4 April 2018

Our Ref: MIN2011/2/2

Modification request to amend the approval for the M2 Site, North Ryde Urban Activation Precinct (SSD5093MOD4)

Drawing Title
Slab on Ground
Plan & Details

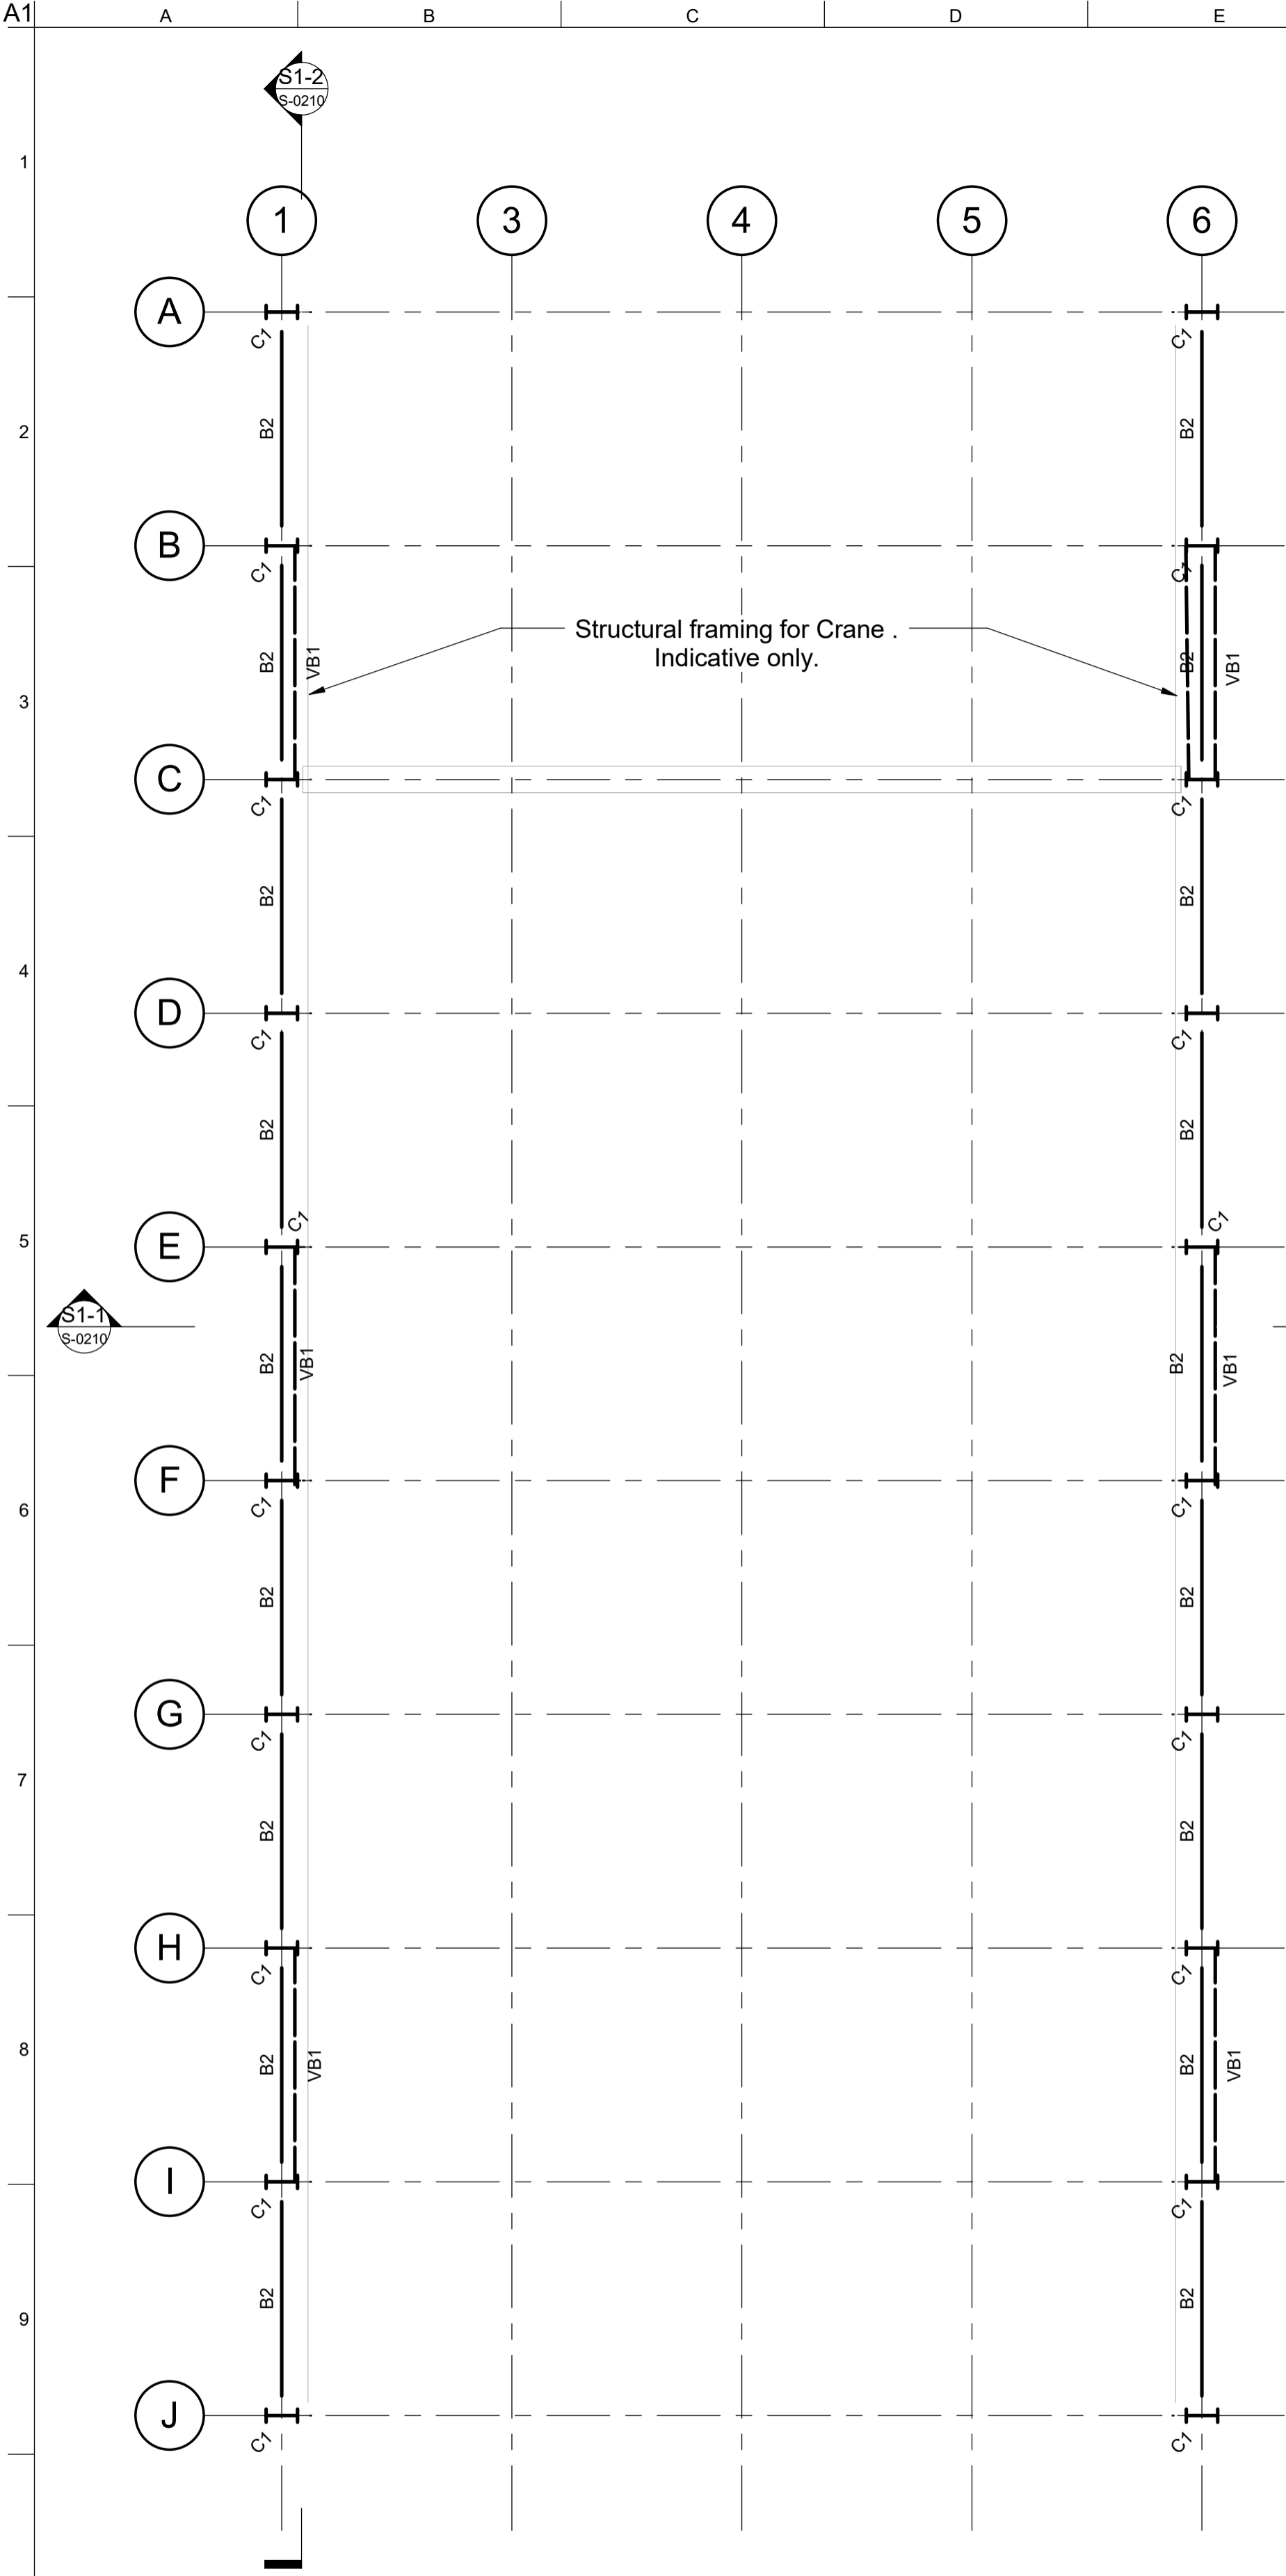
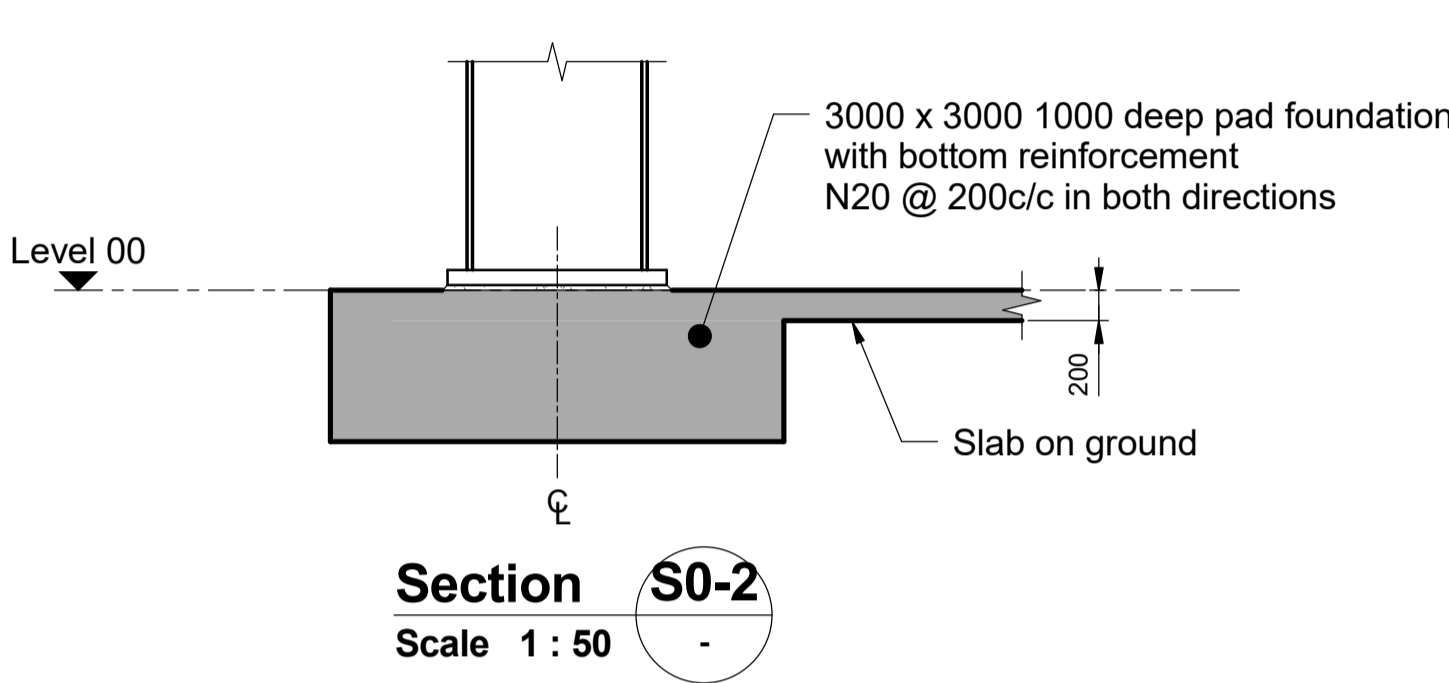
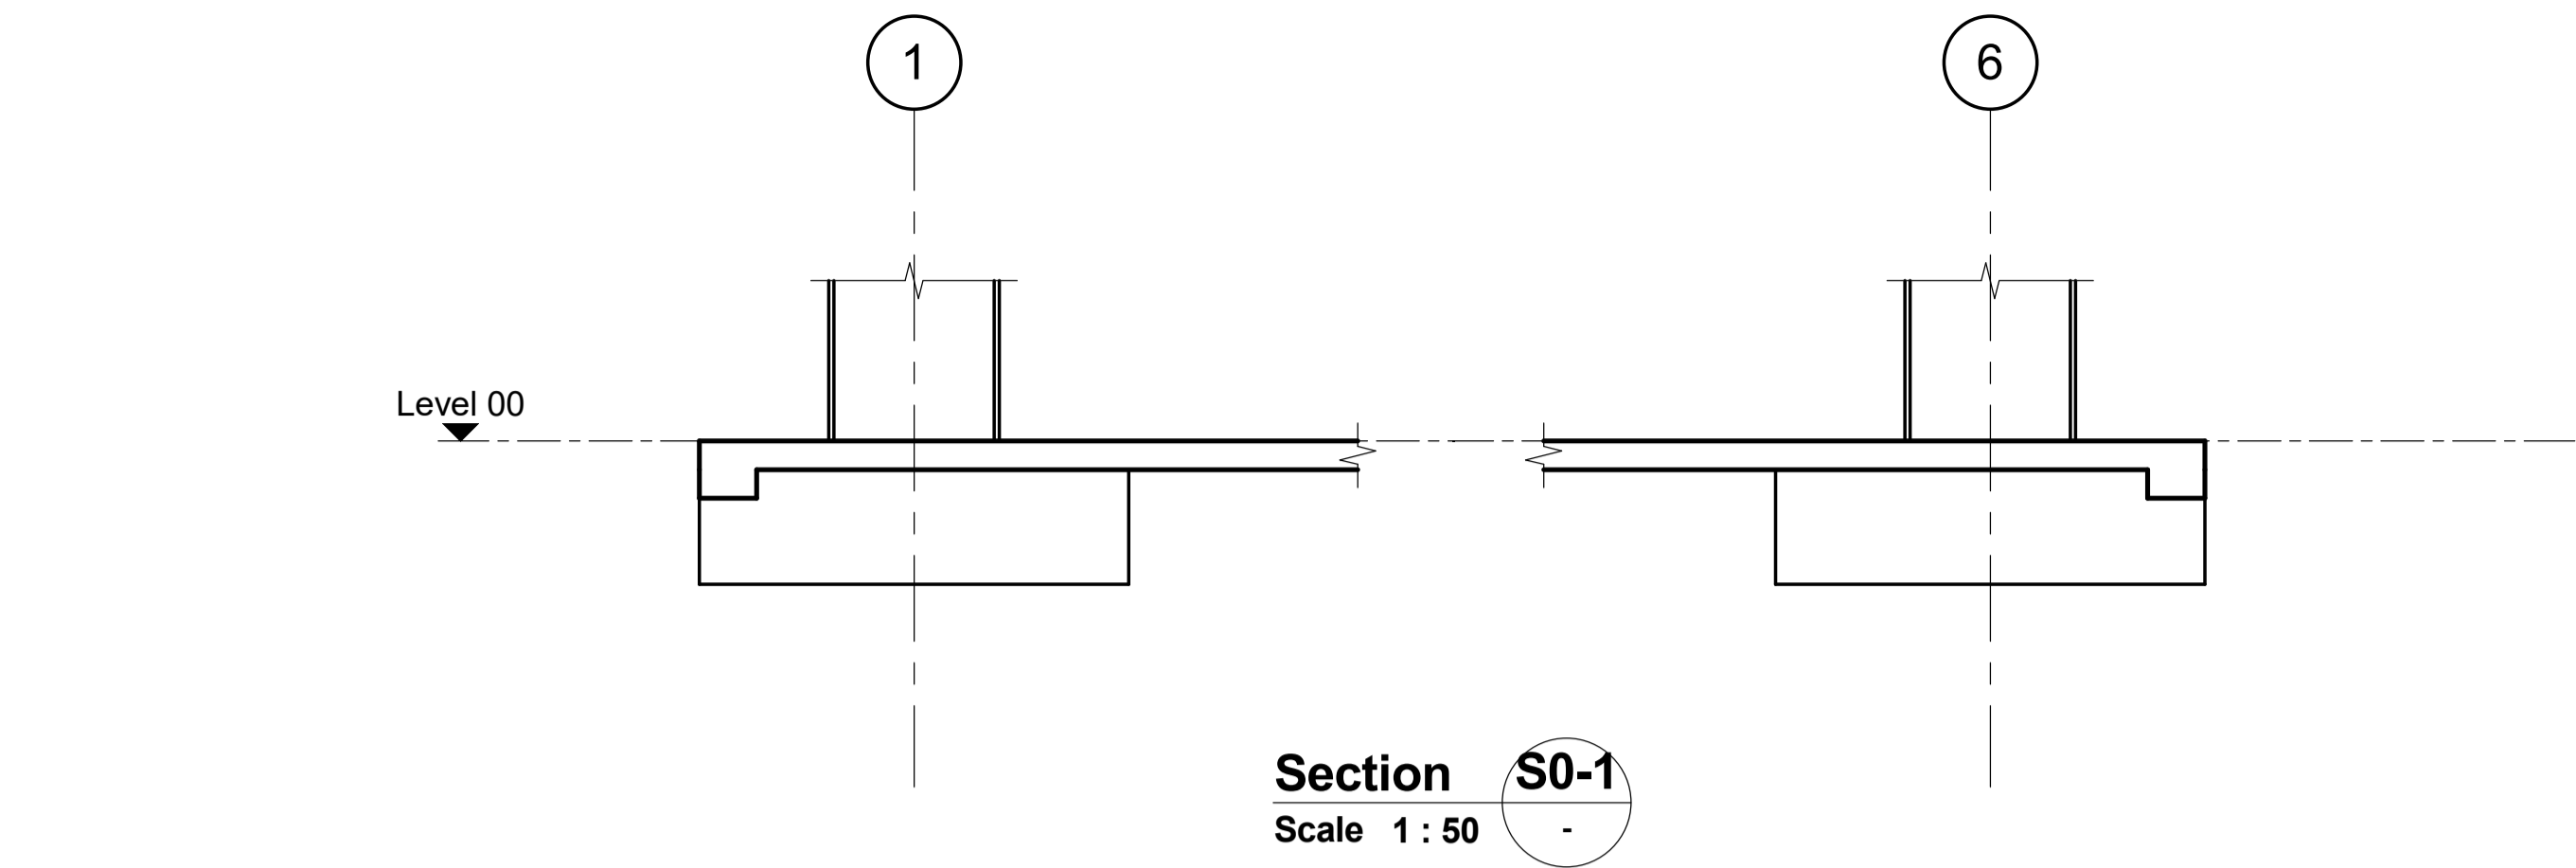
The temporary shed presents a significant expanse of hardstand area (approximately 3,000m²) and will be functioning for approximately 1 – 2 years. In this case, it is considered that the structure's stormwater management system warrants an onsite detention system to be implemented.

The OSD design parameters should be based on Council's detailed design method, which requires stormwater runoff from the works to not exceed the maximum 5yr ARI discharge rate, for all storm events up to 100yr ARI. Given the temporary nature of the project, this could potentially be achieved with 3 above ground tanks in the region of 20,000L storage each, configured as an OSD system at the northern end of the building footprint.

- The stormwater management system for the temporary shed must incorporate an on-site detention system (OSD) to ensure that the stormwater runoff from the works to not exceed the maximum 5yr ARI discharge rate, for all storm events up to 100yr ARI discharge rate. In this case the OSD system may be configured with the installation of above ground tanks to for a storage capacity of 60,000L storage.

PROJECT		NEW DEVELOPMENT			
DRAWING		TREE LOCATION PLAN - PIER 2			
SCALE	N.T.S. @ A3	ISSUE	REF		SHEET
DRAWN		CHECK		DATE	REVISION
LD+AM		AM		11-04-18	H

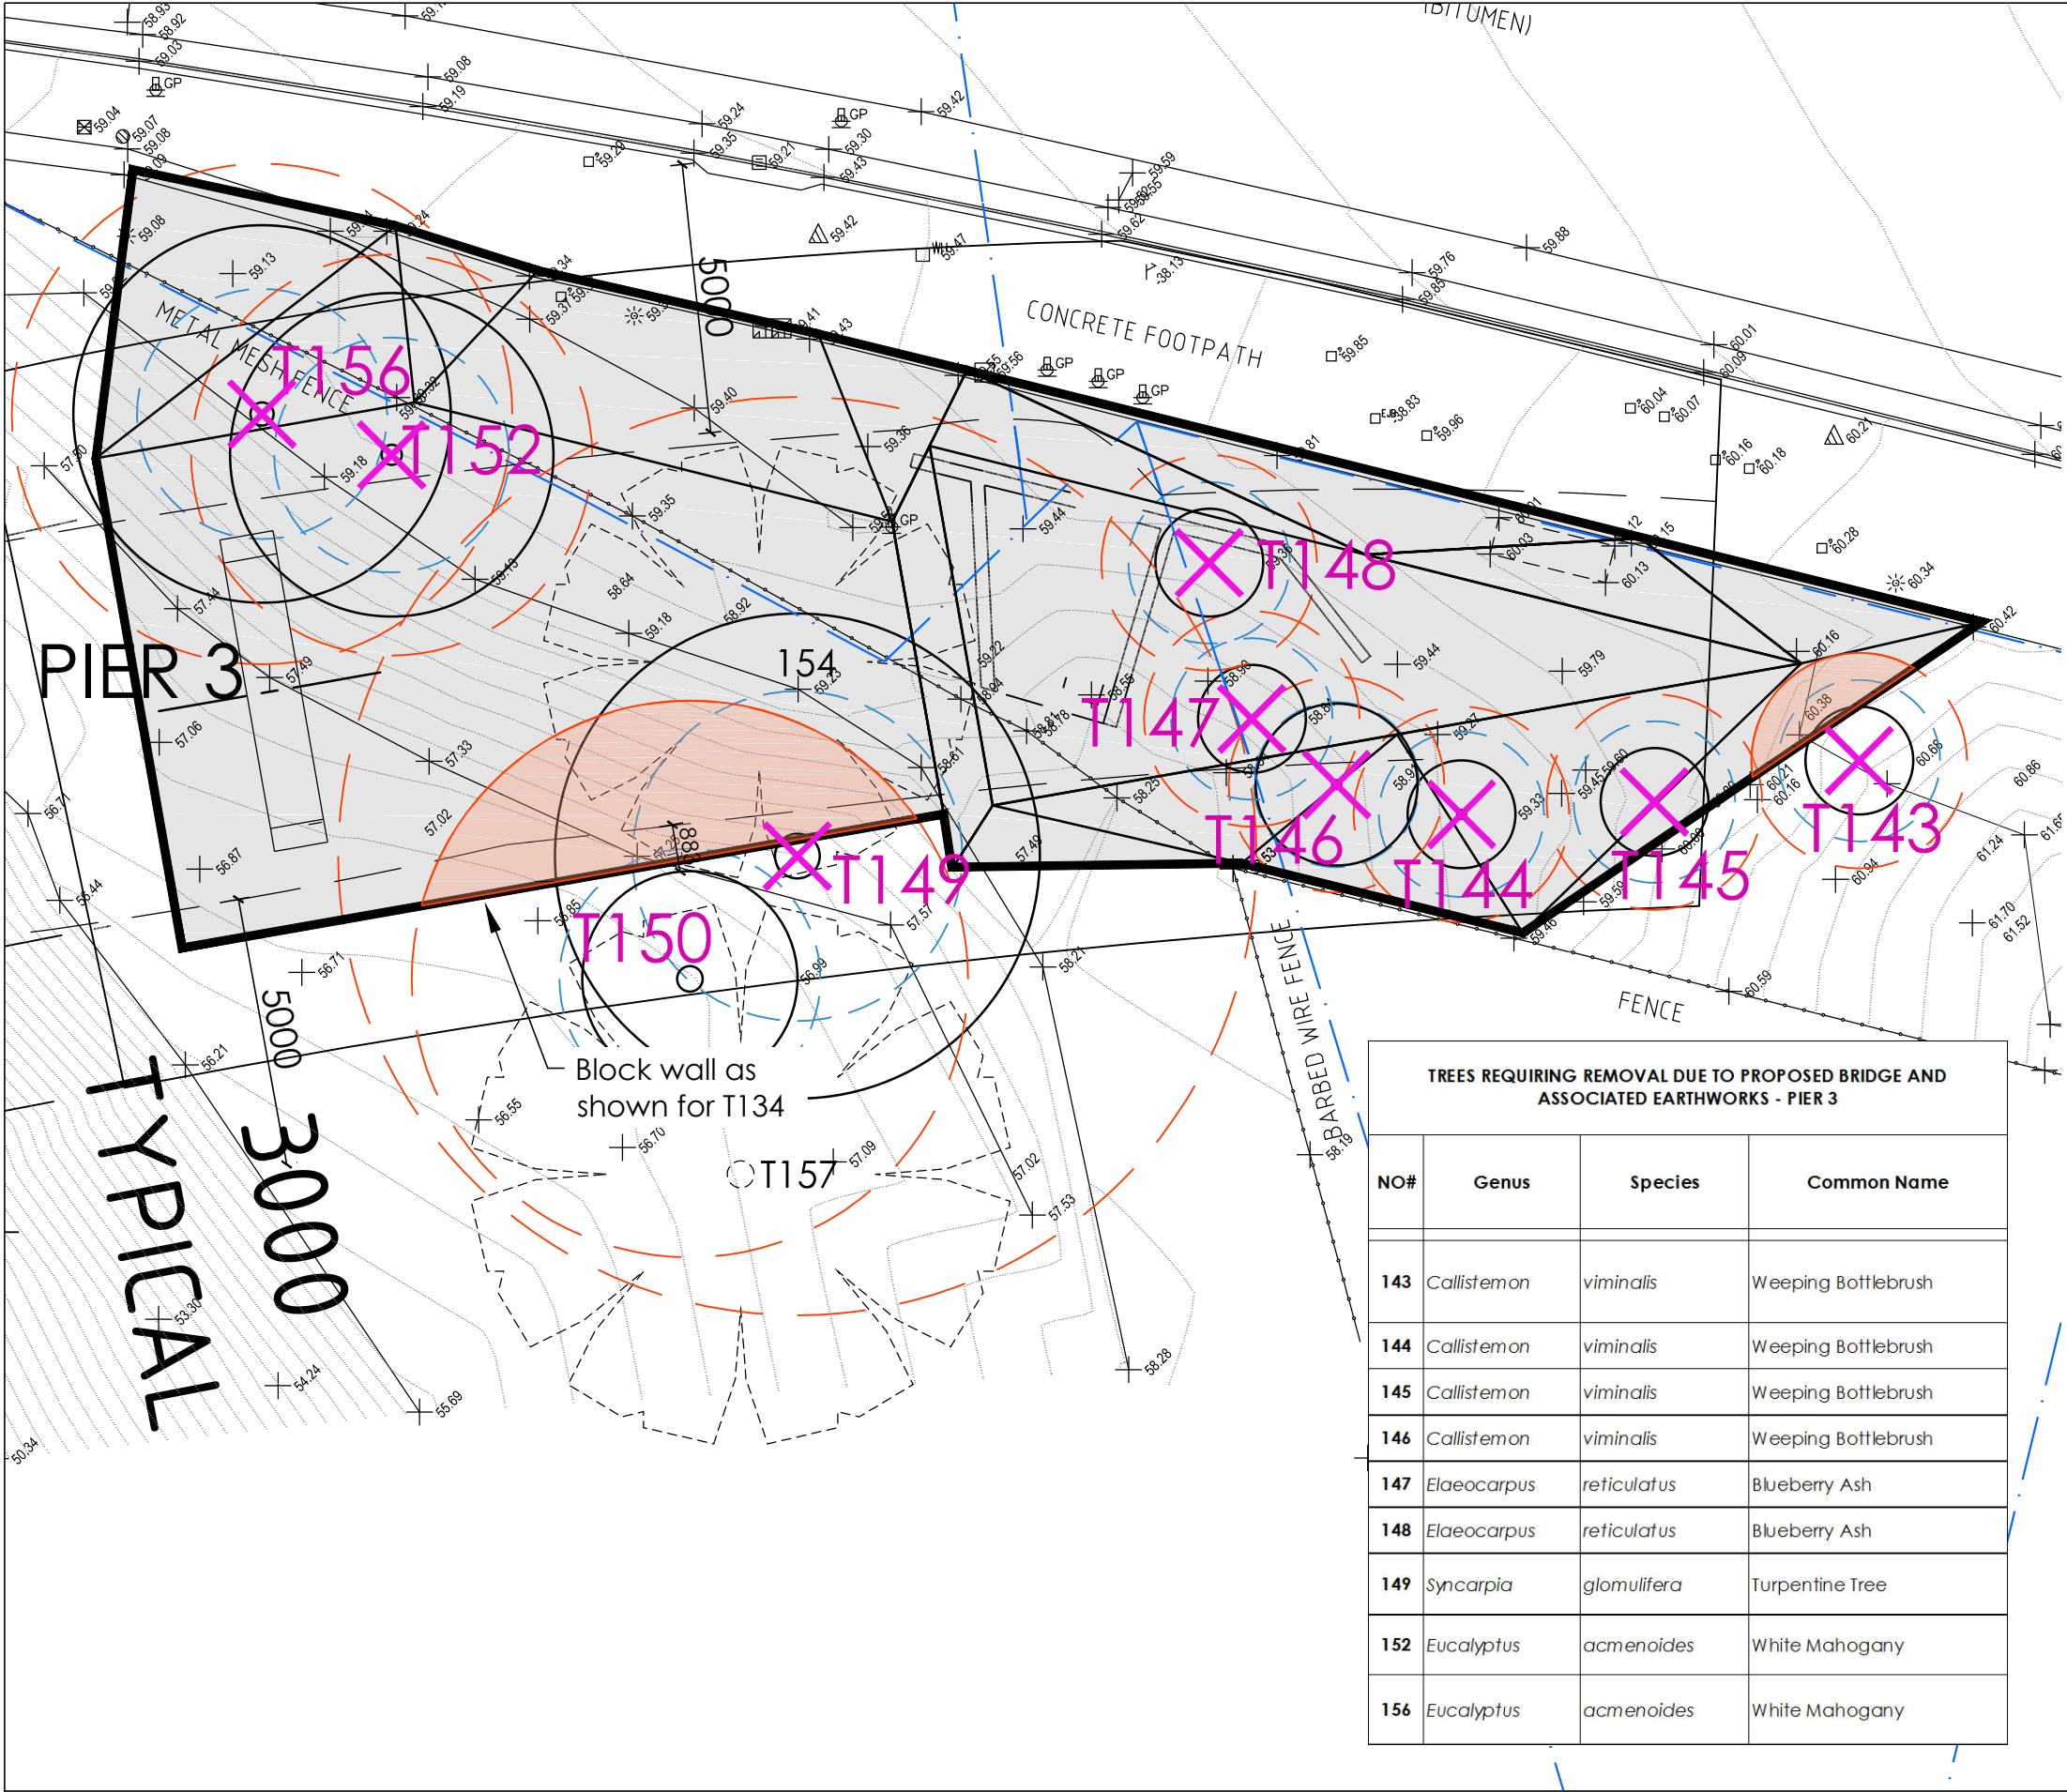
Council in its submission dated 30 October 2014 raised concerns that the original SSDA proposal did not adequately consider the potential impacts upon Bundara Reserve. The accompanying plans of the bridge and the structural report were also unclear to accurately determine if the piers would be located outside or inside the Bundara Reserve. It is noted from the modification plans that pier 2 would be located within the reserve which would require removal of trees from the reserve.

Council strongly objects to the proposed tree removal from Bundara Reserve for the reasons stated below.

Other options should be explored in relation to the bridge design and alignment. There should be no net loss of biodiversity and no tree removals as a result of the construction of a pedestrian bridge.
